# ENG-SF22023-R1-FDR.pdf Markup Summary

**Subject:** EPC ENG Review  
**Page Index:** 1  
**Date:** 8/19/2022 2:53:24 PM  
**Author:** dsdrice  
**Color:** ■  
**Layer:**  
**Space:**  
**Page Label:** 1

FALCON MEADOWS AT BENT GRASS FILING NO. 4

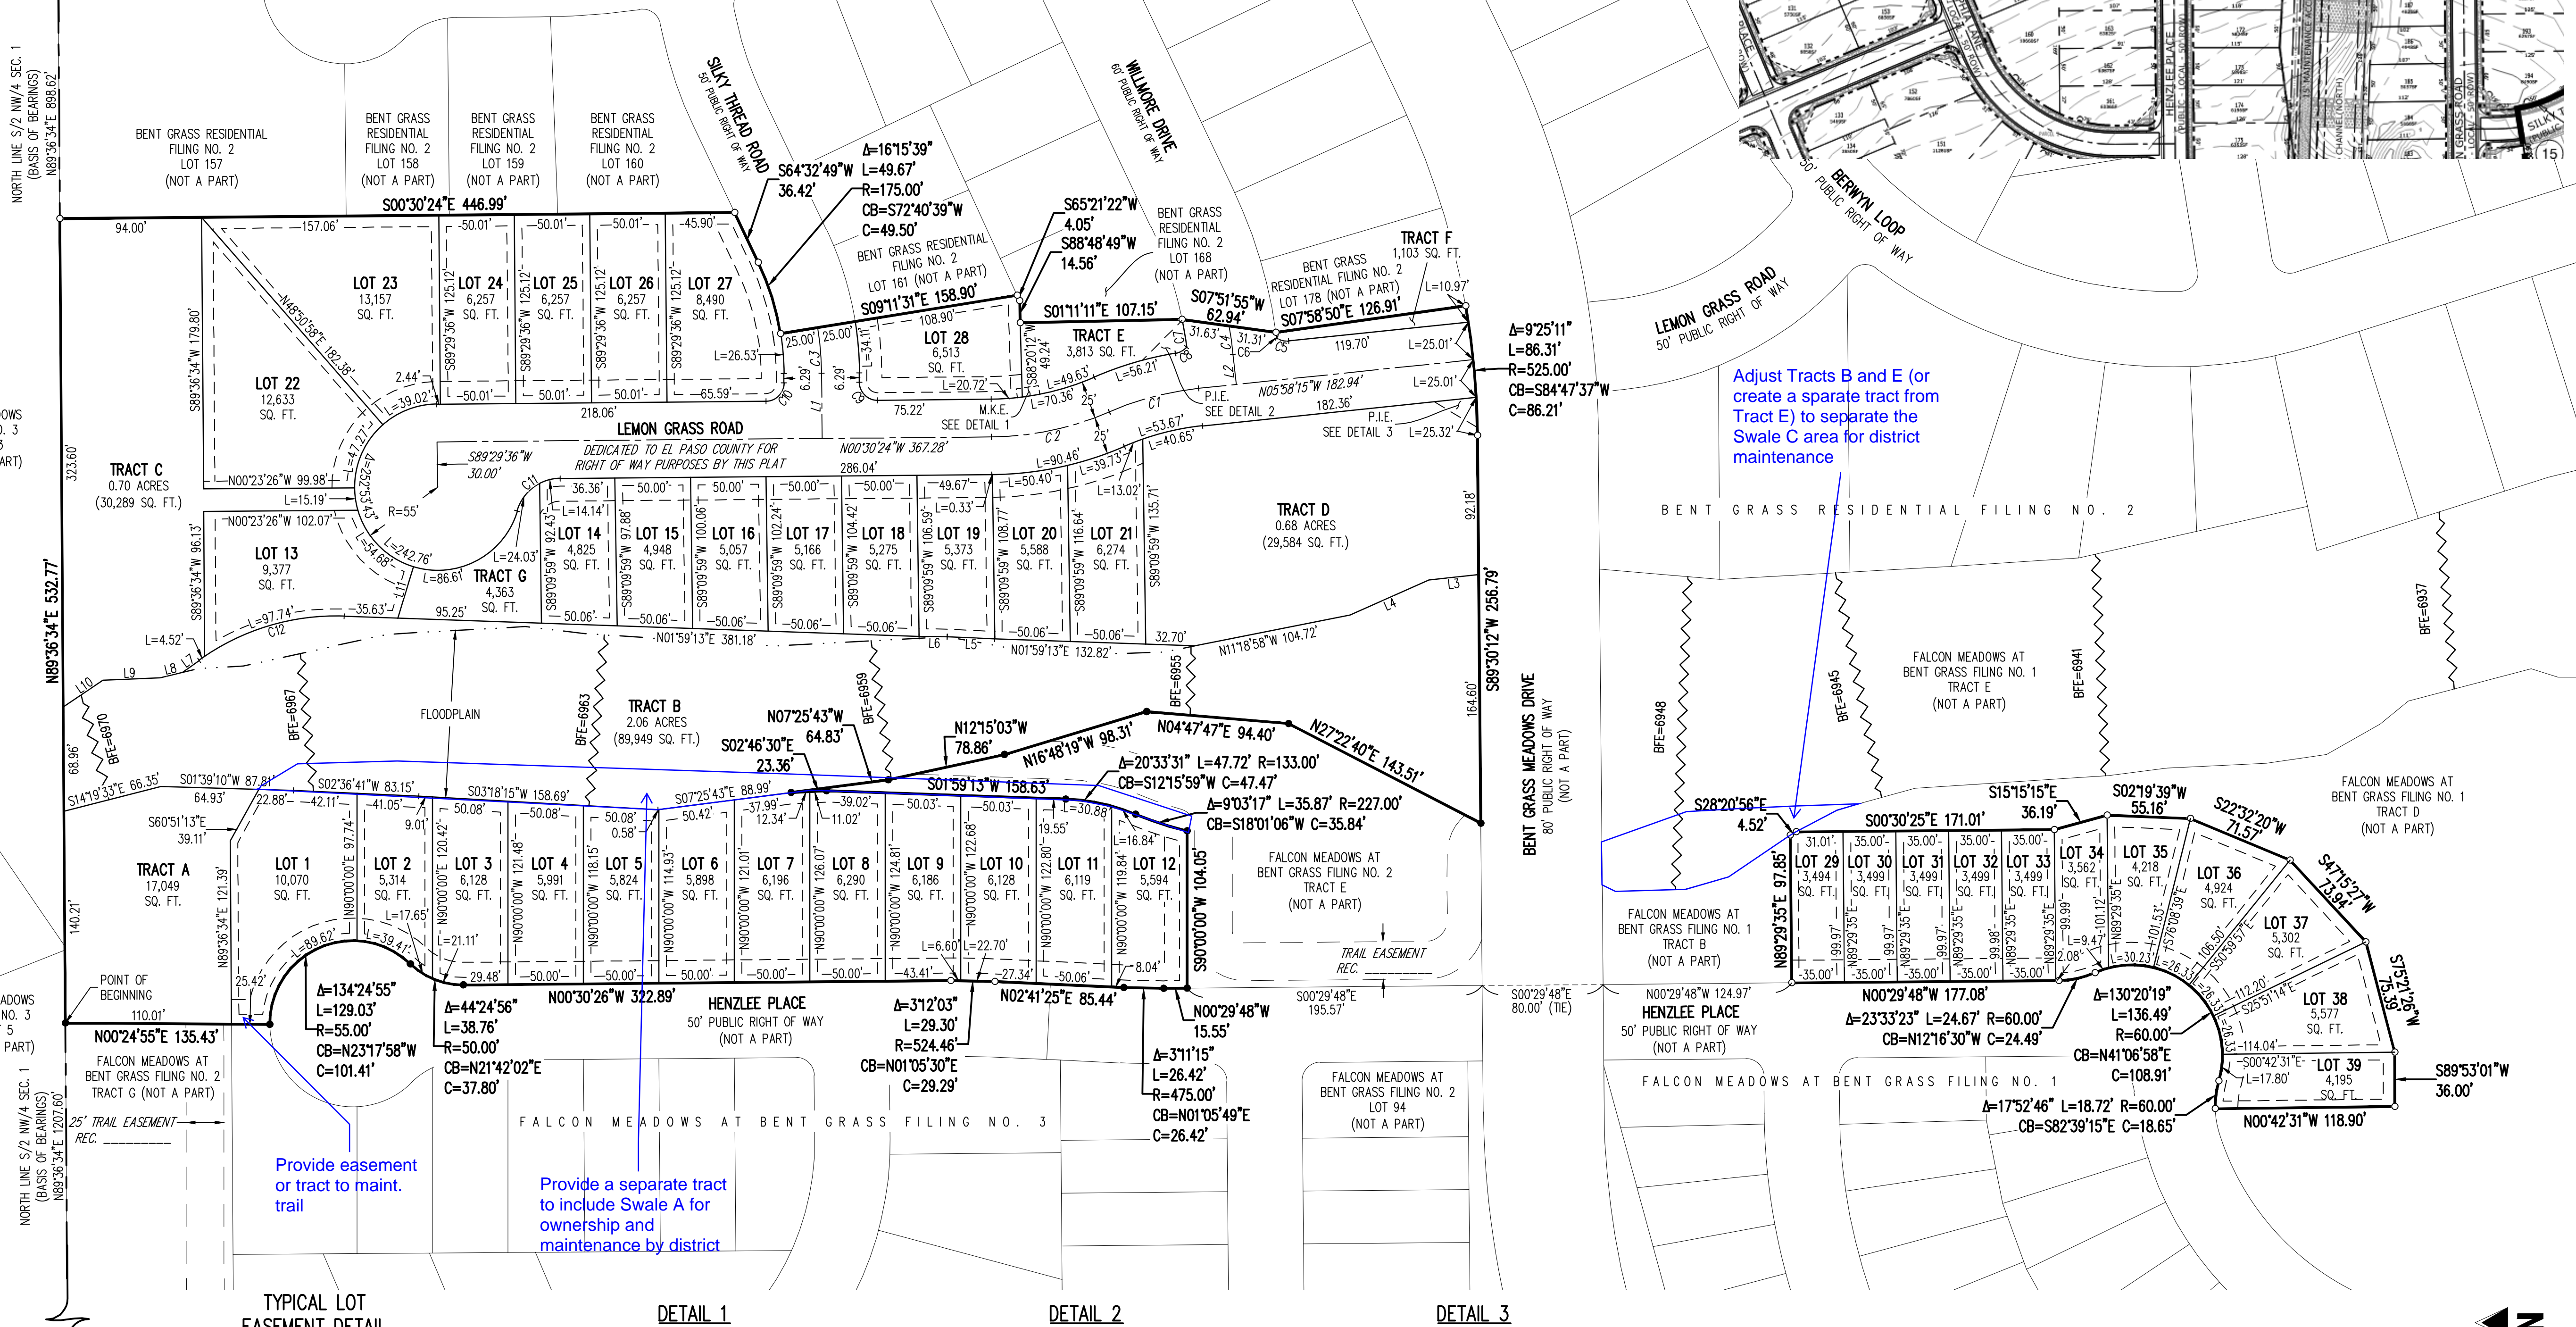
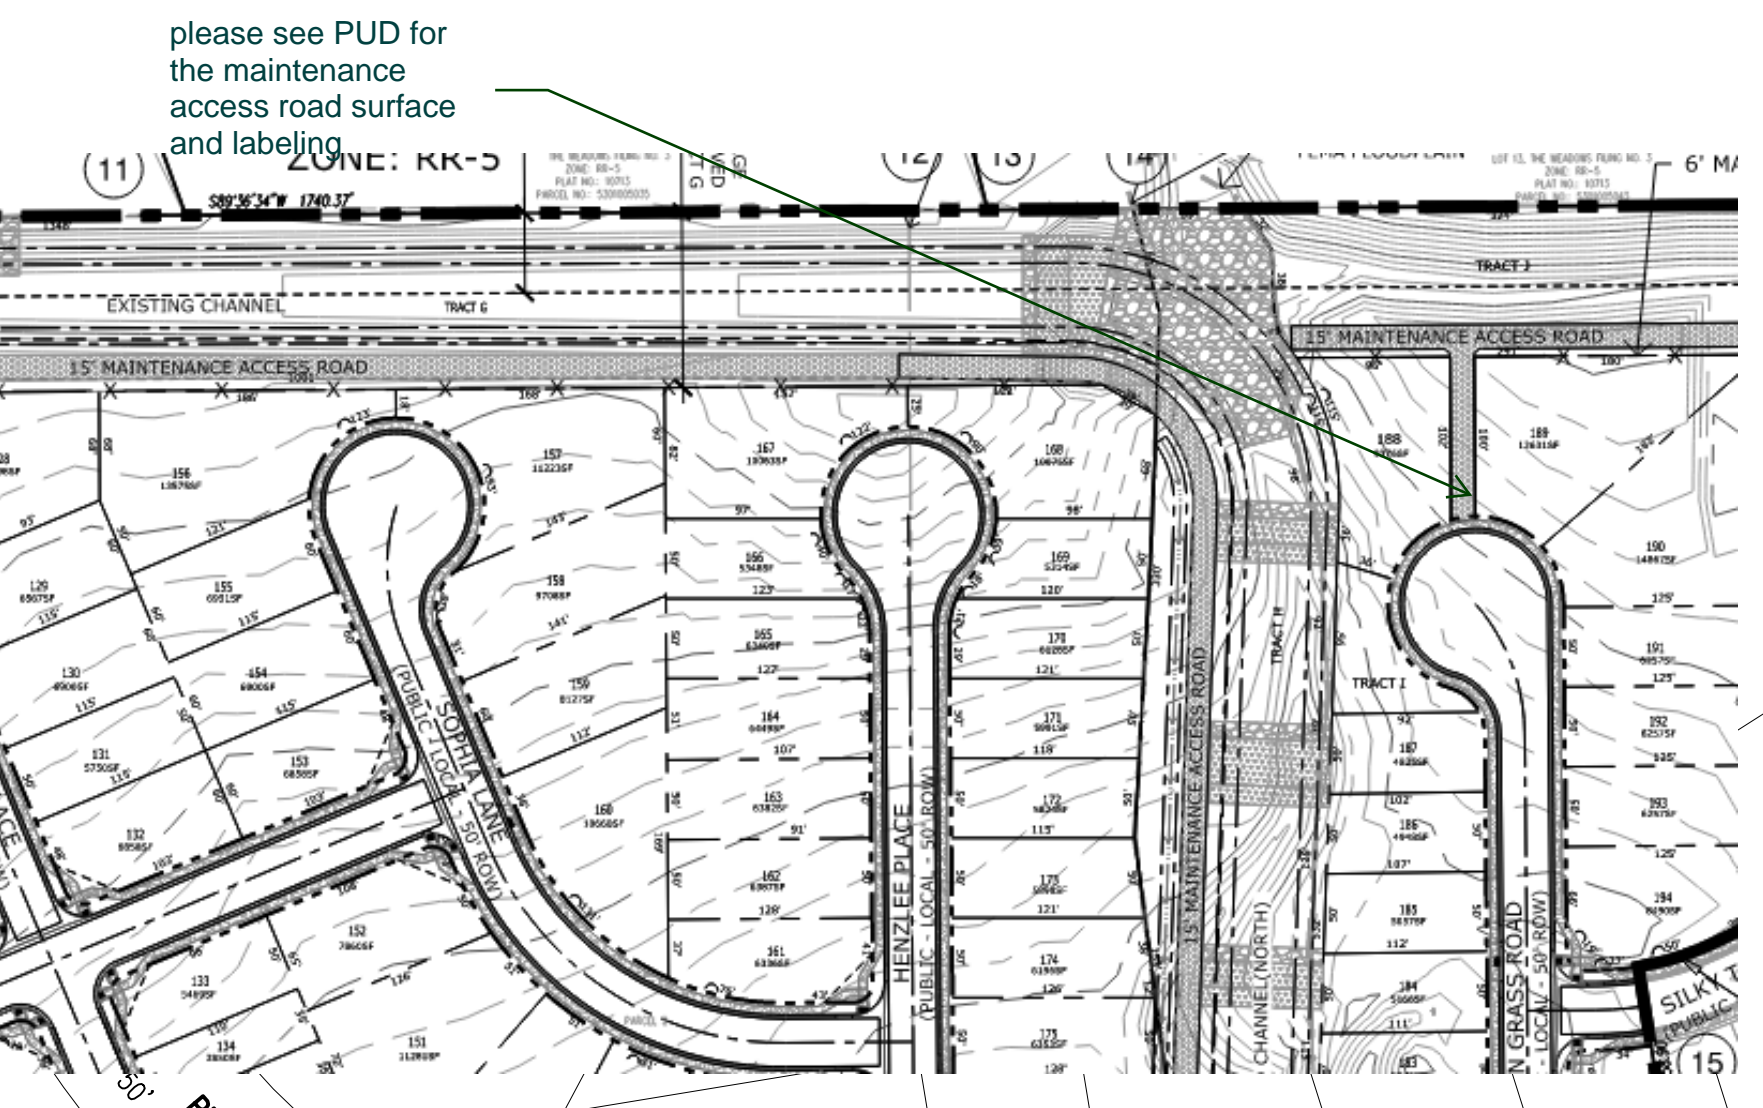
Provide a separate tract to include Swale A for ownership and maintenance by district
